Application No: FG/57/22/PL
Site Address: 12 Little Paddocks Ferring BN12 5NJ
Description of works: Demolition and erection of 1 No new dwelling. This application is in CIL Zone 4 and is CIL Liable as new dwelling.

Thank you for your internet representation made on 12th May 2022 which has been recorded as an objection with the comments as follows:

Re 12 Little Paddocks, Ferring/Application No. FG/57/22/PL

DRAWING No.
**Drawing 1
Existing & Proposed
Floor Plans & Elevations**

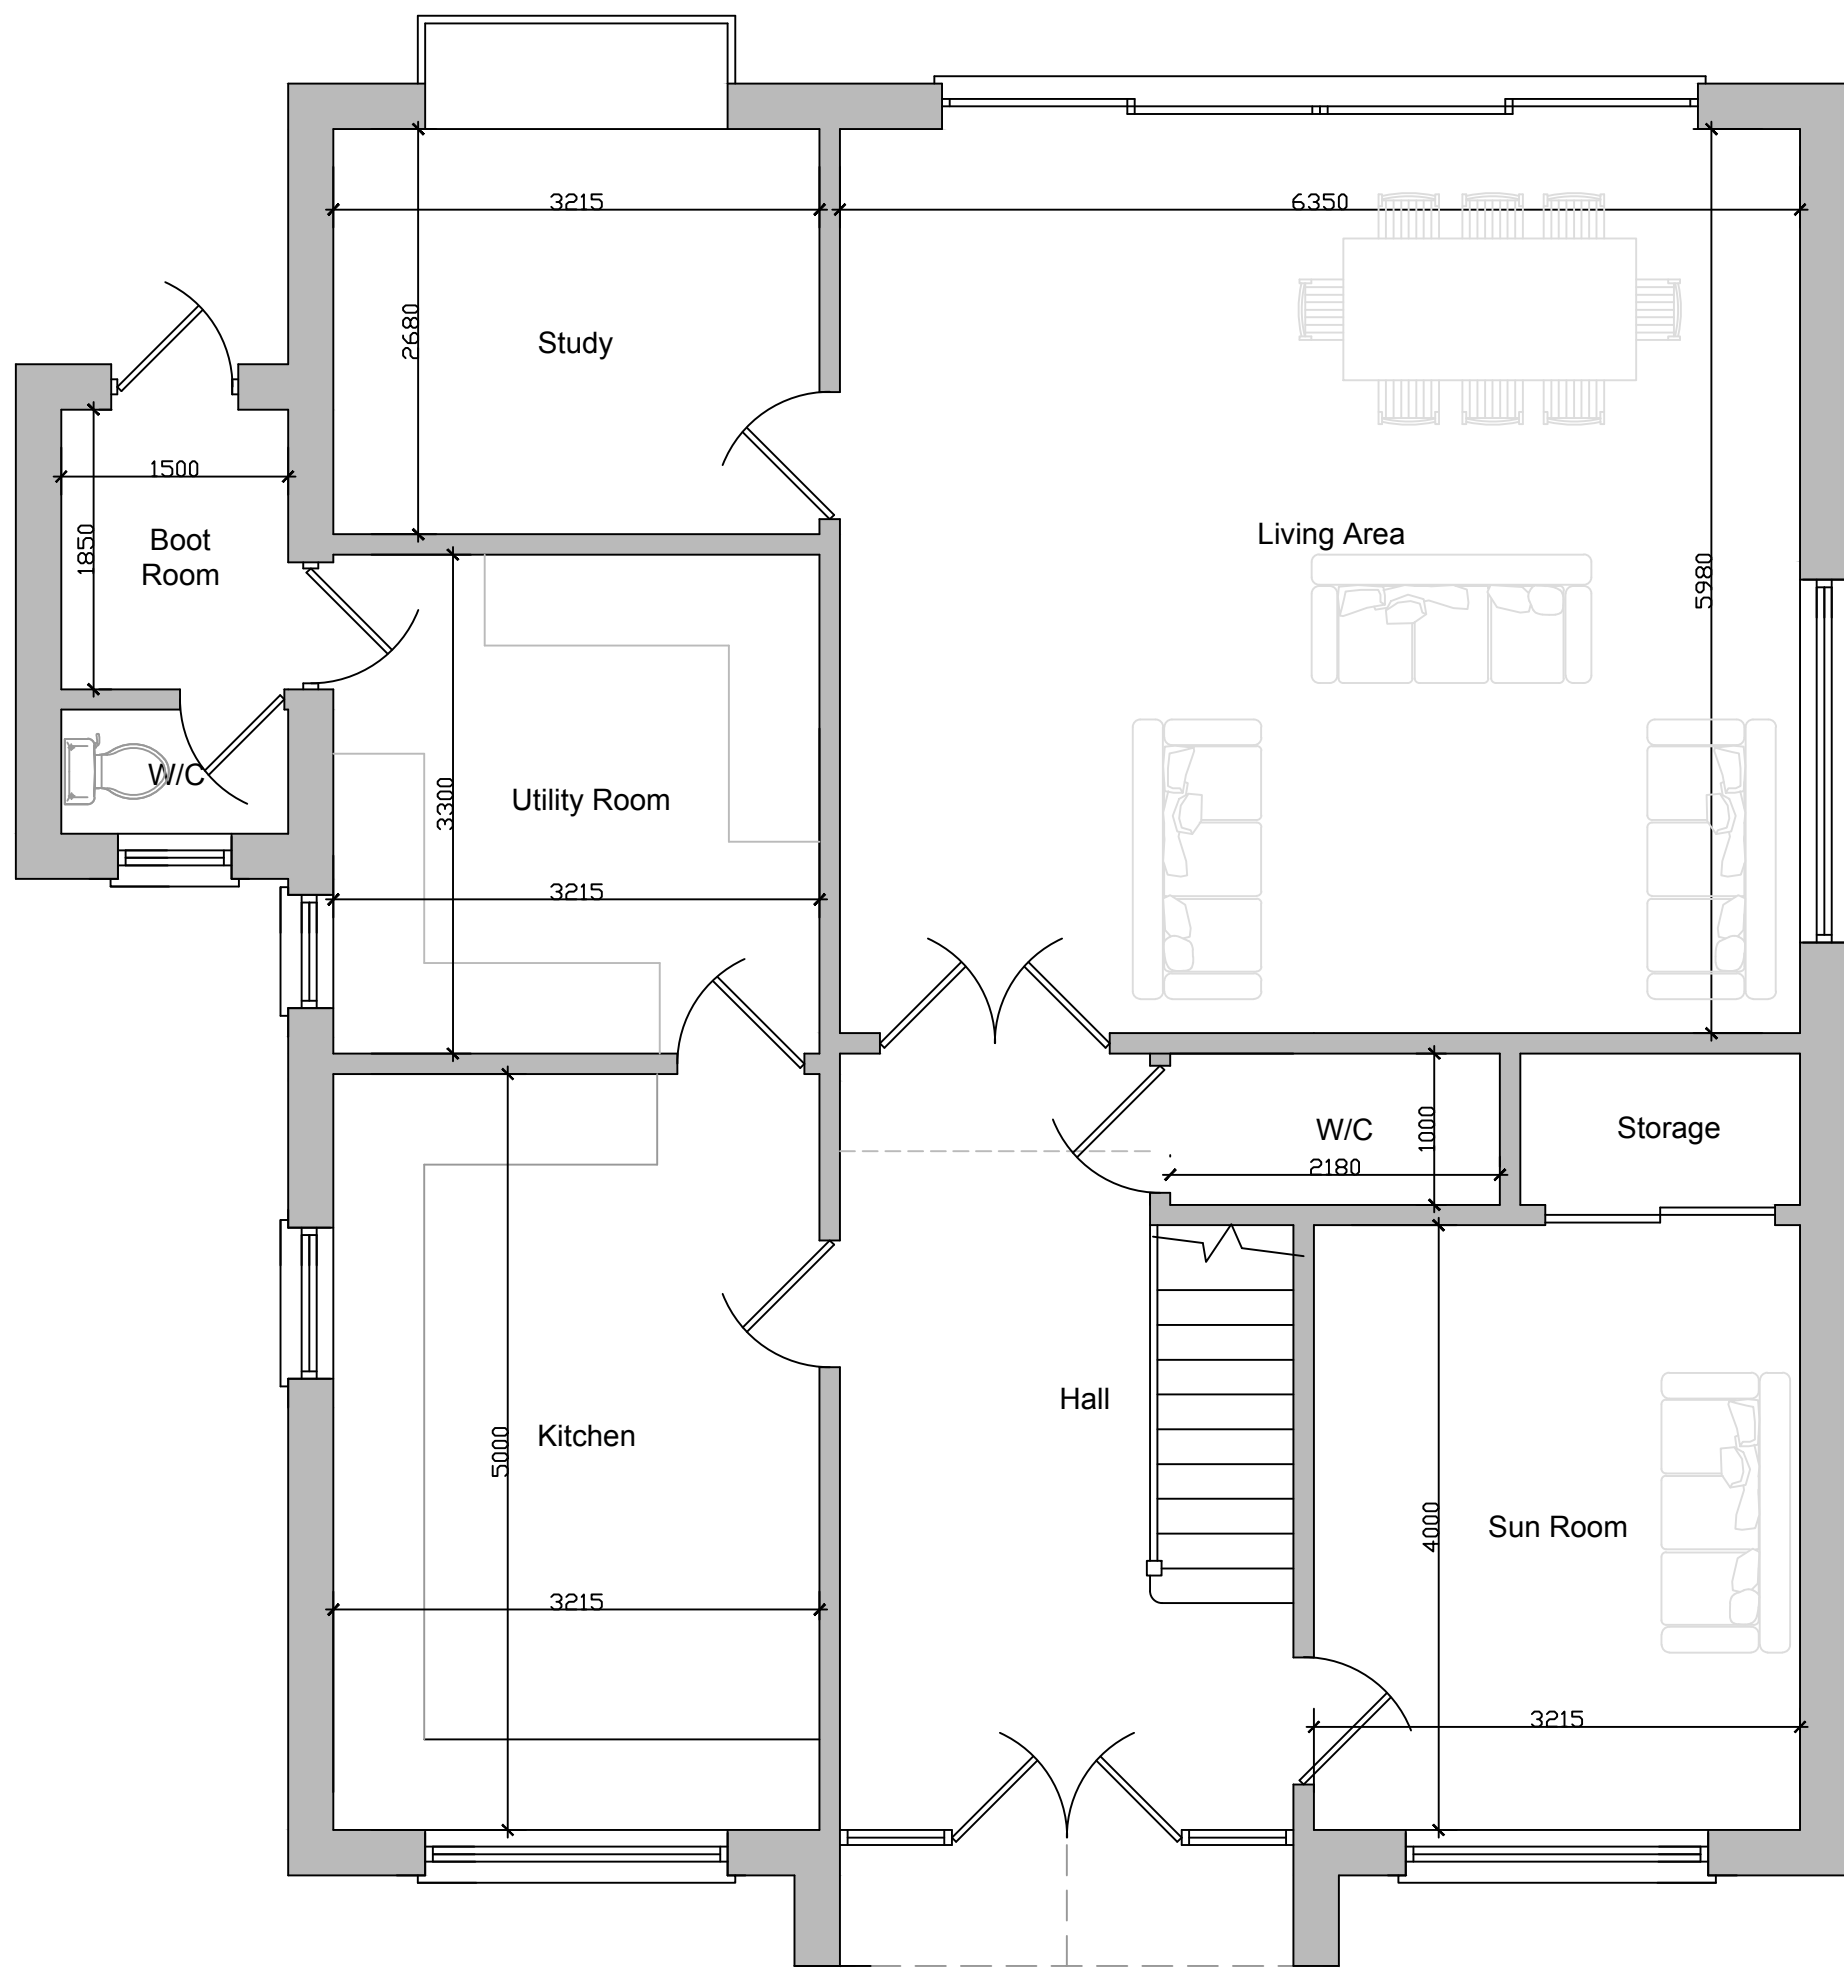
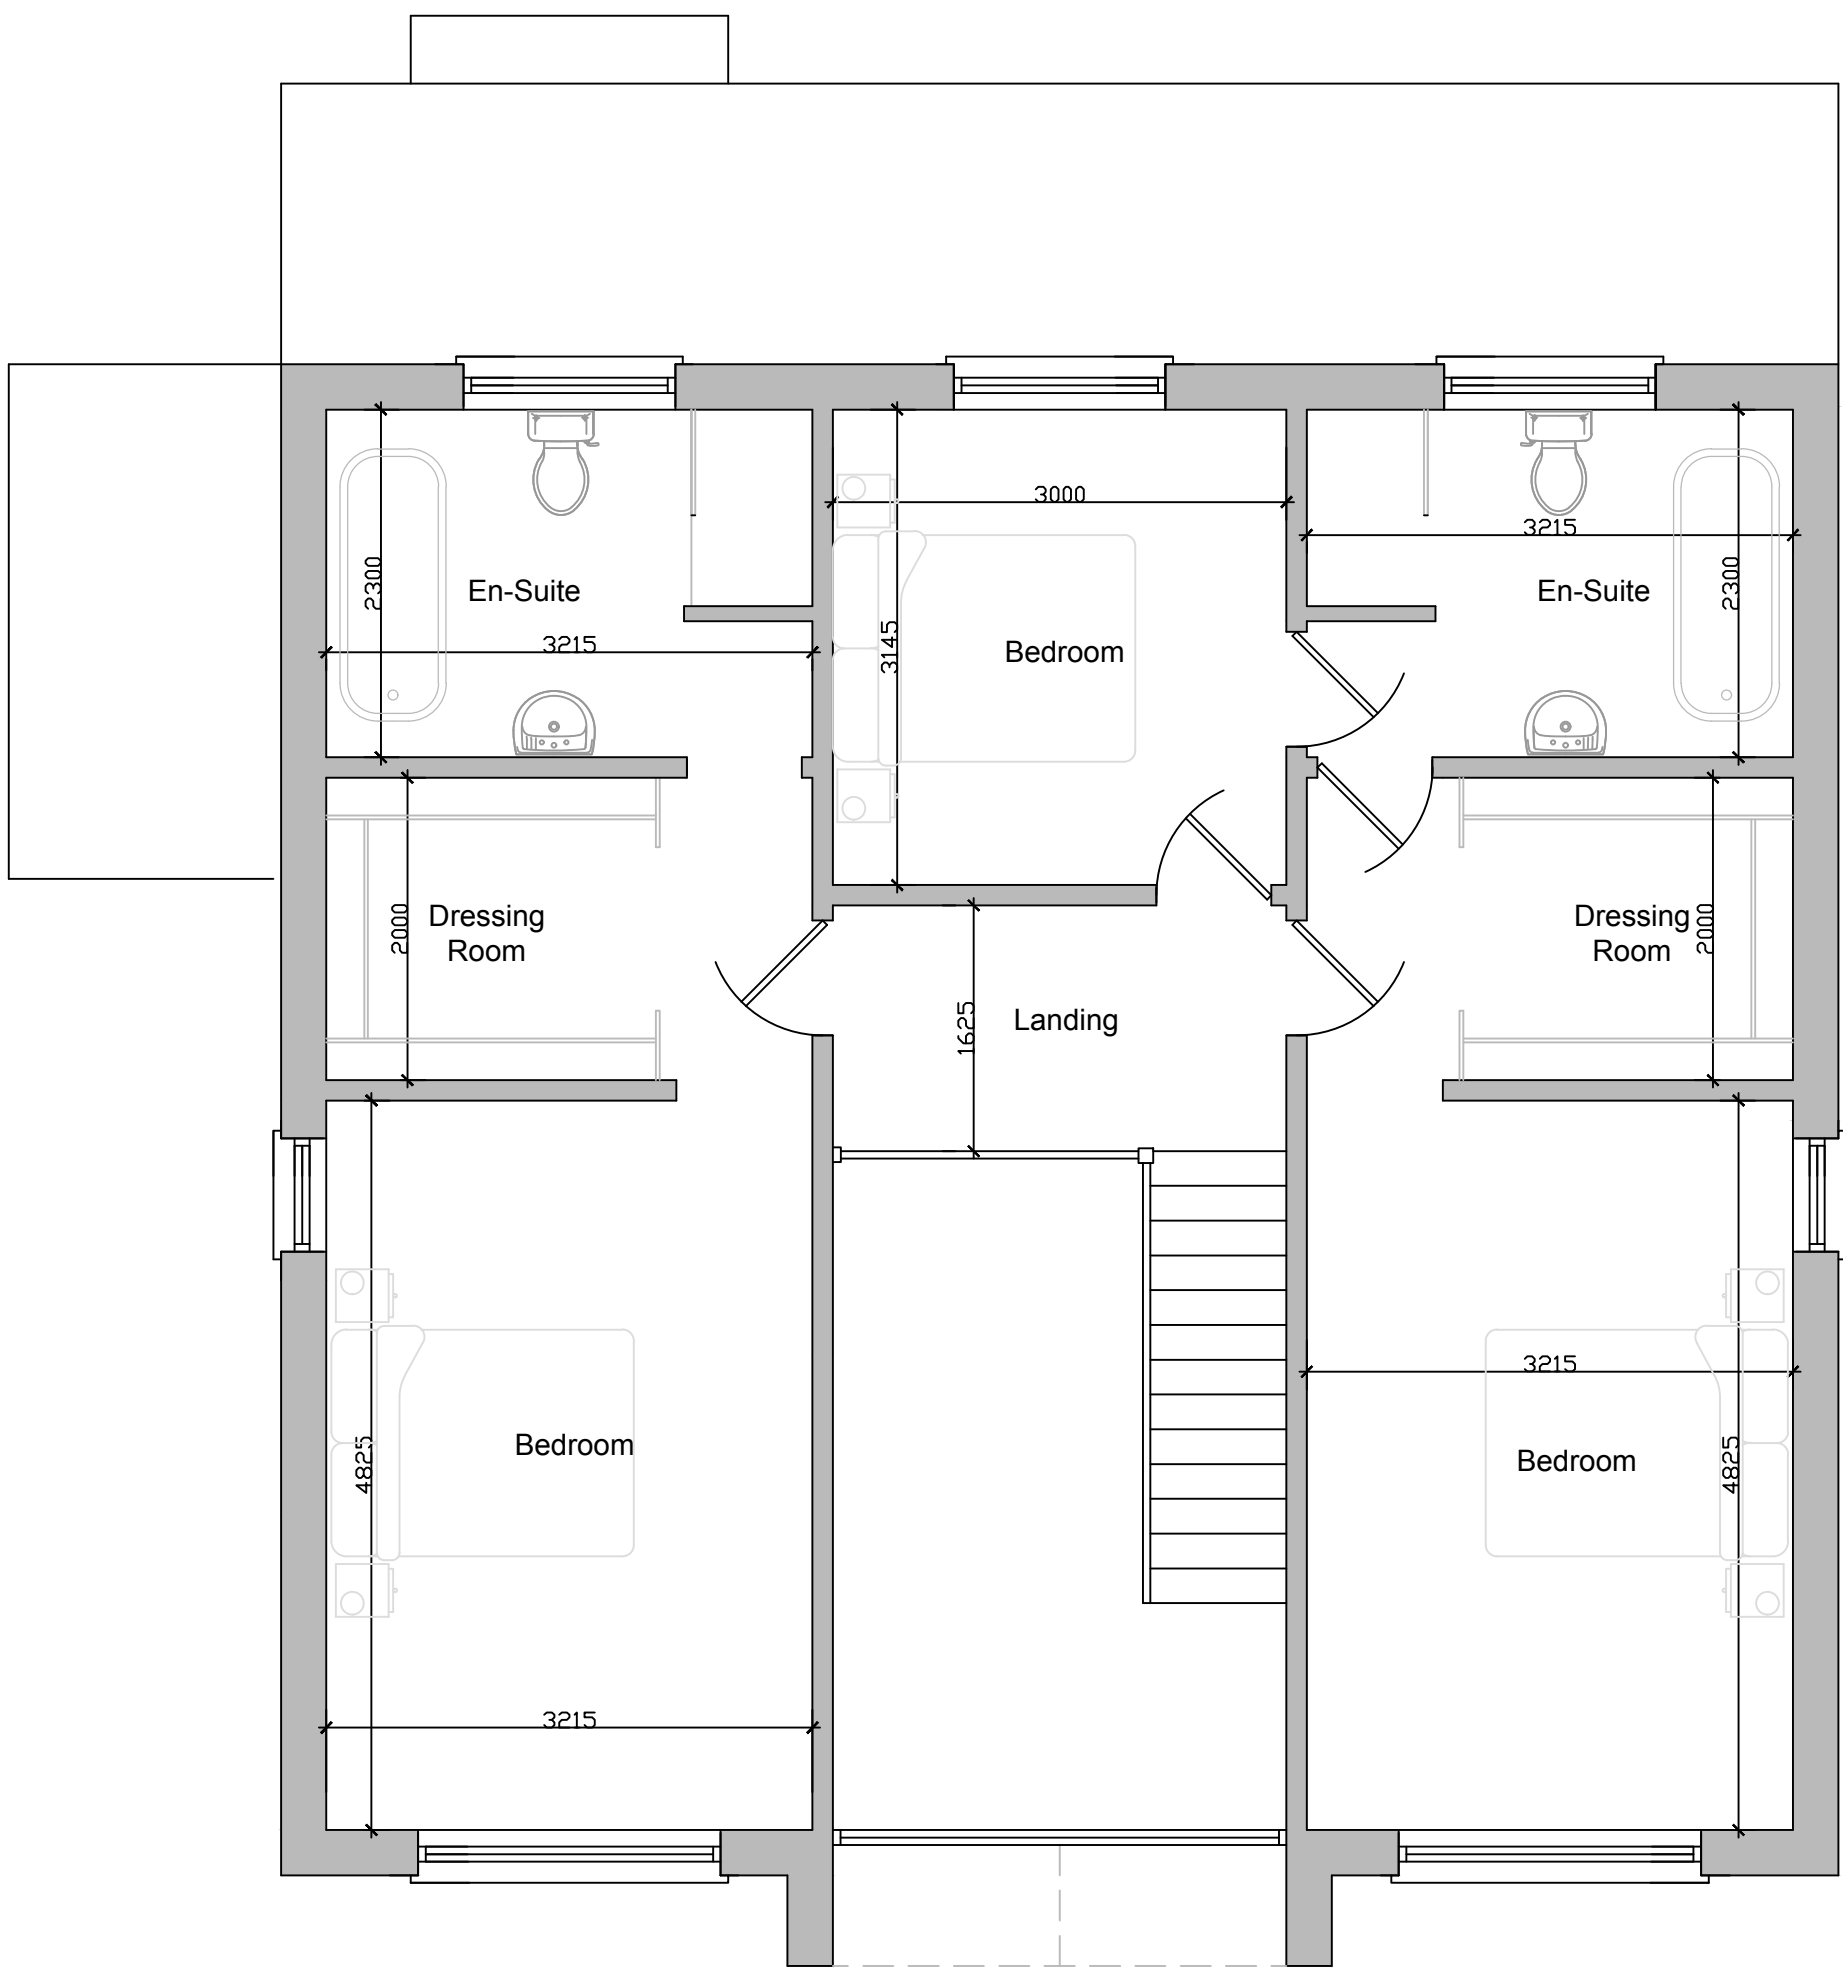
I accept and support the principle of development but this proposal will directly impact my property and personal space causing a loss to my residential amenity. I have taken advice, best I can, and I have read that existing planning policy seeks to ensure that such amenity is protected (from the plan it appears that the bedroom window looks directly into my garden, lounge area and principle bedroom).

Hard to see given these considerations that the relationship between my property and the proposed development meets these requirements. The development clearly would result in an unacceptable impact upon me and I therefore object to this application. In coming to this decision and having reviewed the plans the situation can be avoided by the removal of the first floor east elevation bedroom window.
